To: All Staff
From: Environmental Health
Date: October 23, 2025
Subject: AU-25-00009 Bollinger

SITE PLAN

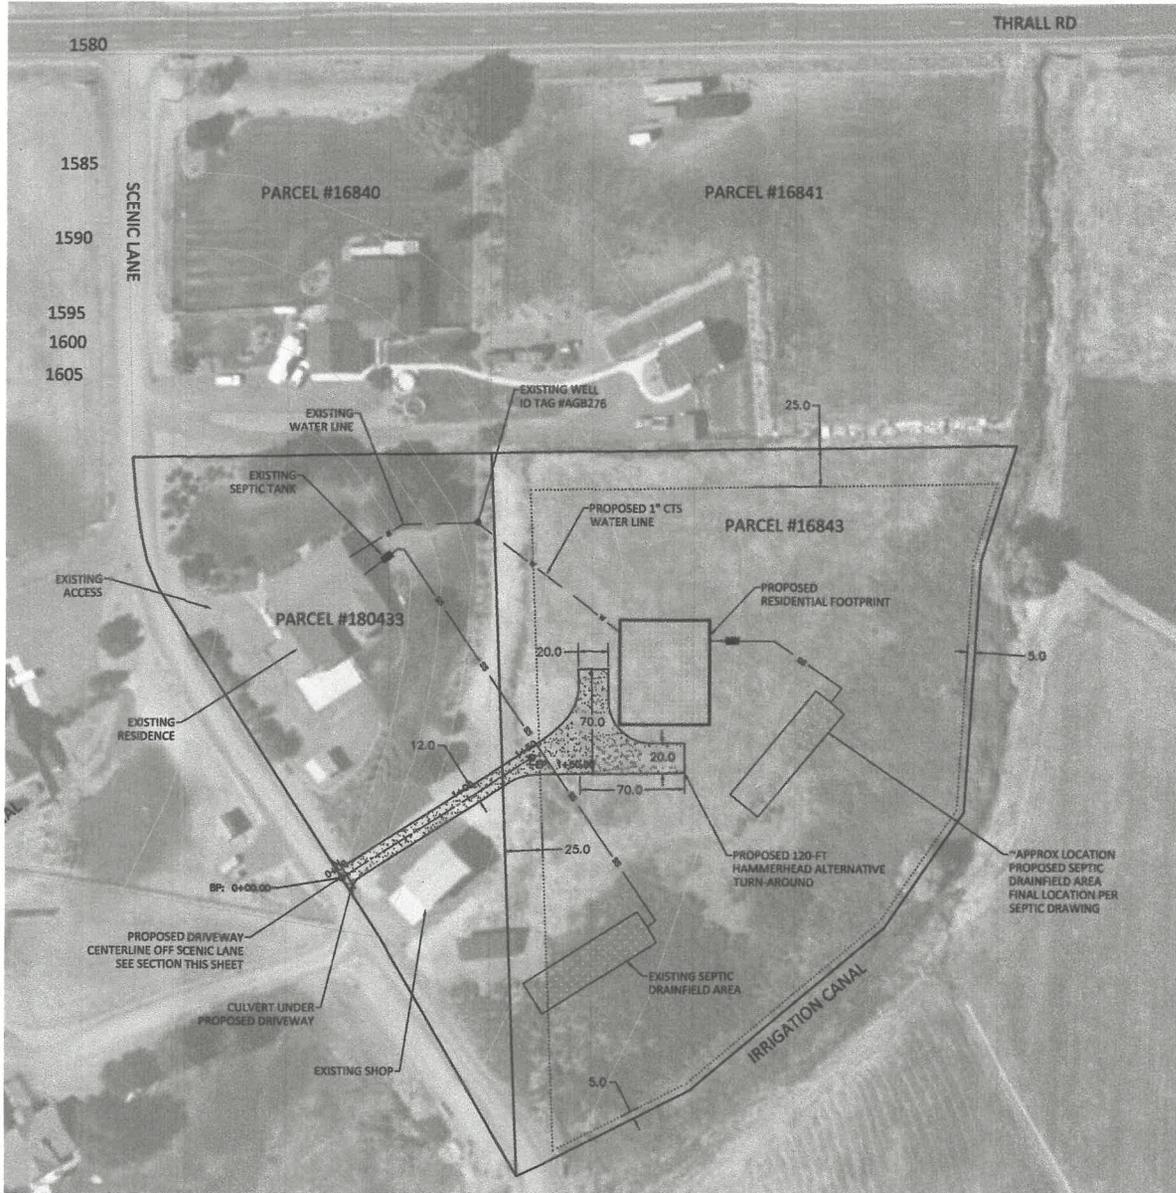
Drinking Water	<ul style="list-style-type: none">• AWSI I/S is needed for the proposed structure.• A shared well users' agreement is needed since it appears the well will be shared
Wastewater	<ul style="list-style-type: none">• A site evaluation for the new structure is needed to determine soil type for proposed septic system.• A design from a licensed-on site septic designer along with installation permit is needed for the proposed septic system.
